S. R. Marmon Neighborhood Association
P. O. Box 7434
Albuquerque, New Mexico 87194

6 January 2025

Re: PR-2023-008674

Plat for
 Playa Del Sur
 Being Comprised of
 Portions of Tracts 308, 309 and
 310, Unit 8, Town of Atrisco Grant
 City of Albuquerque
 Bernalillo County, New Mexico
 January 2024

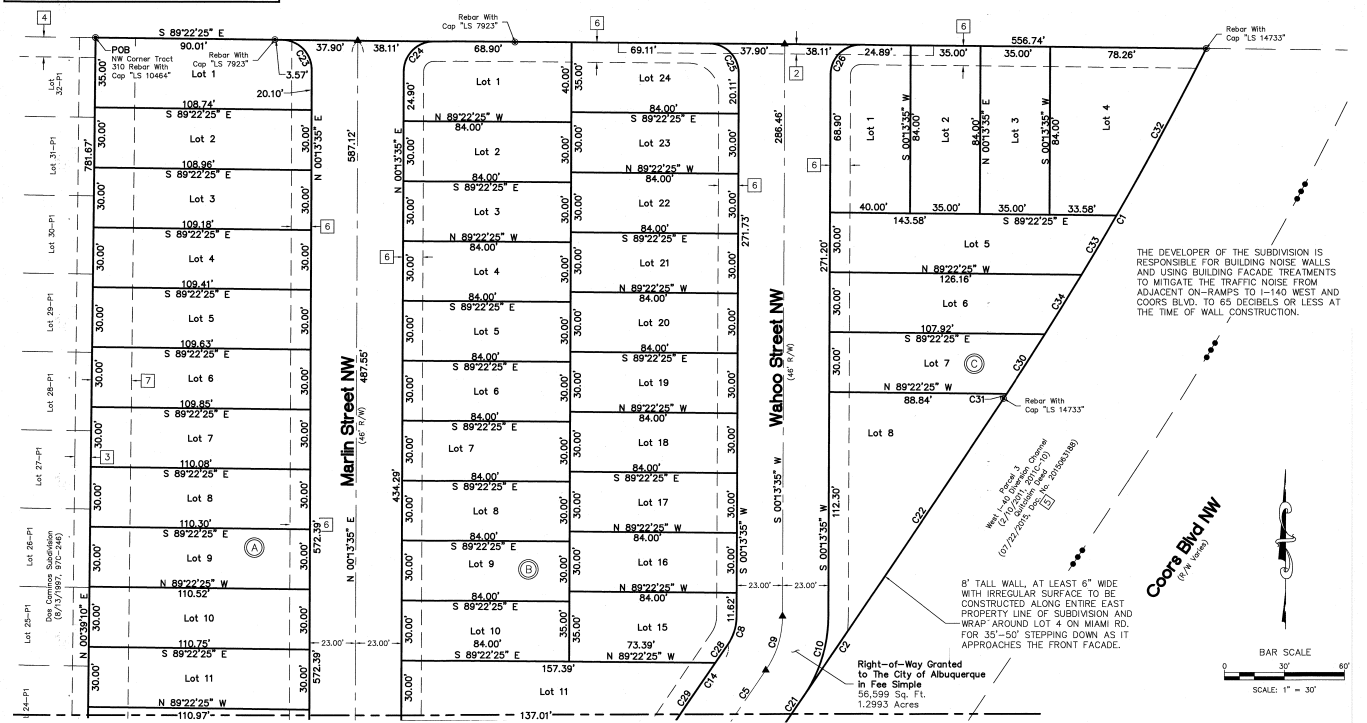
Tierra West, L. L. C., acting as agent for property owner Butterfly Holdings, L. L. C., indicates that no front wall variance is required for the front wall facing Miami Road NW because the property is zoned MX-T. Both the 2022 and 2023 IDO indicate that the maximum wall height for low-density residential development in a mixed-use zone is three feet if within 10 feet of the lot line abutting the street and six feet if farther away. The required 8-ft wall exceeds these heights and requires the owner/agent/developer to seek a variance. Please see Table 5-7-1 Maximum Wall Height on page 322 in the applicable IDO and page 326 in the 2023 IDO.

Per the IDO, a variance is required for the wall that has been constructed along Miami Road NW. Per the submitted plan, this wall is a front wall and violates city ordinance. The applicant has failed to comply with all conditions of approval for the preliminary plat.
